Your ref: 3/2023/0695
Our ref: DC/23/3123 v2
Date: 28-DEC-23

Location: Stanley House Preston New Road Mellor BB2 7NP

Proposal: Approval of details reserved by condition 4 (drainage) of planning permission 3/2020/1059.

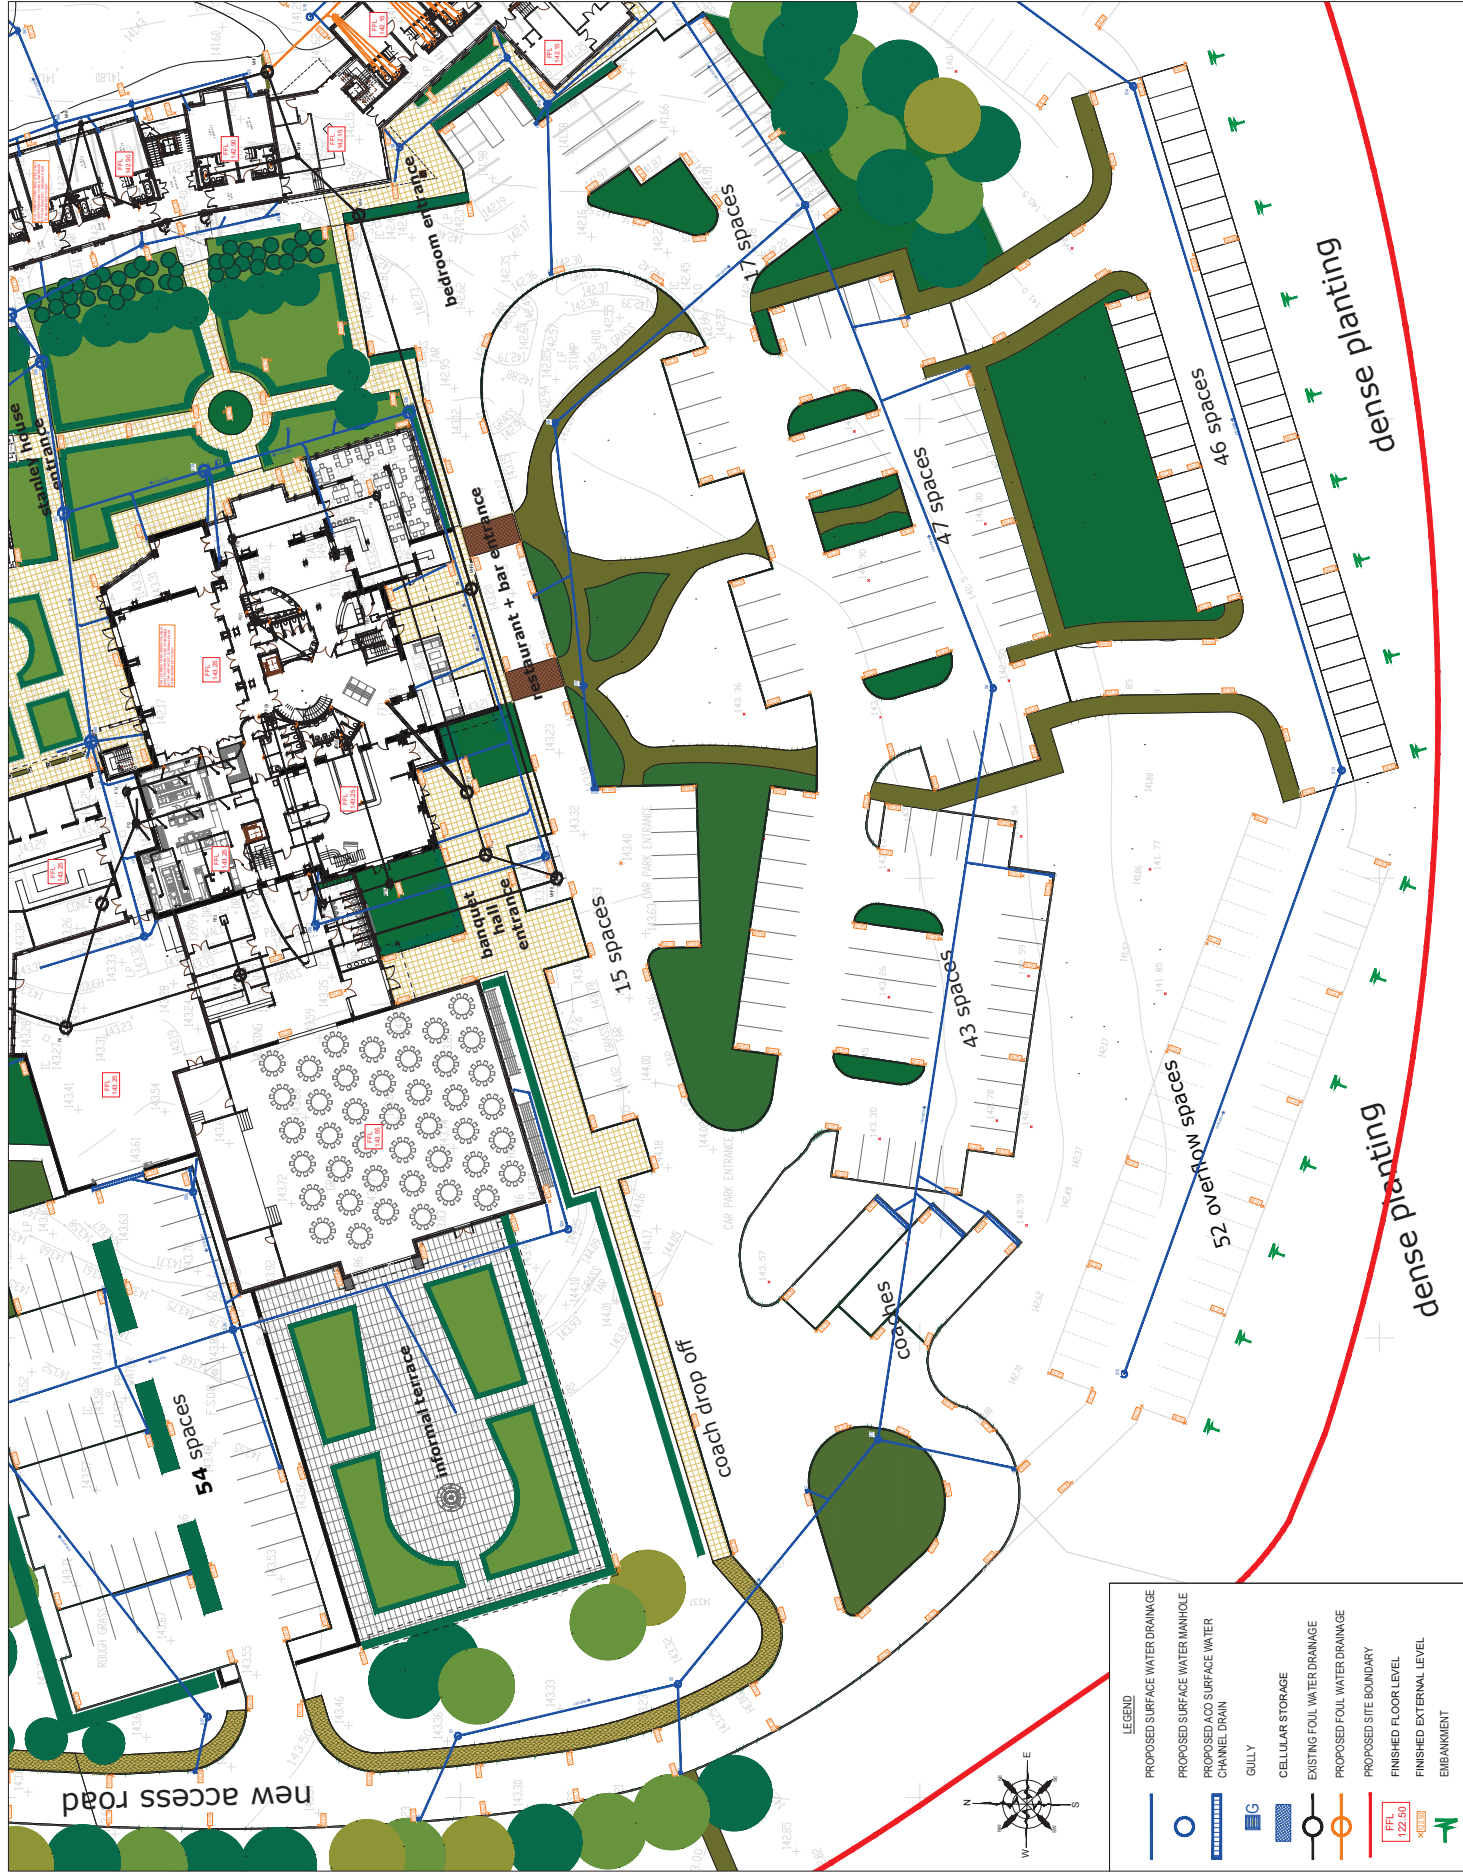
Further to our review of the submitted documents, Drawing LM_23004-101, Rev P1 - Dated 31.07.2023, United Utilities recommends that condition 4 is not discharged. The plan provided is not clear, the outfall point indicated is not to a public sewer.

Can the applicant advise where their waste water discharges into the public system.
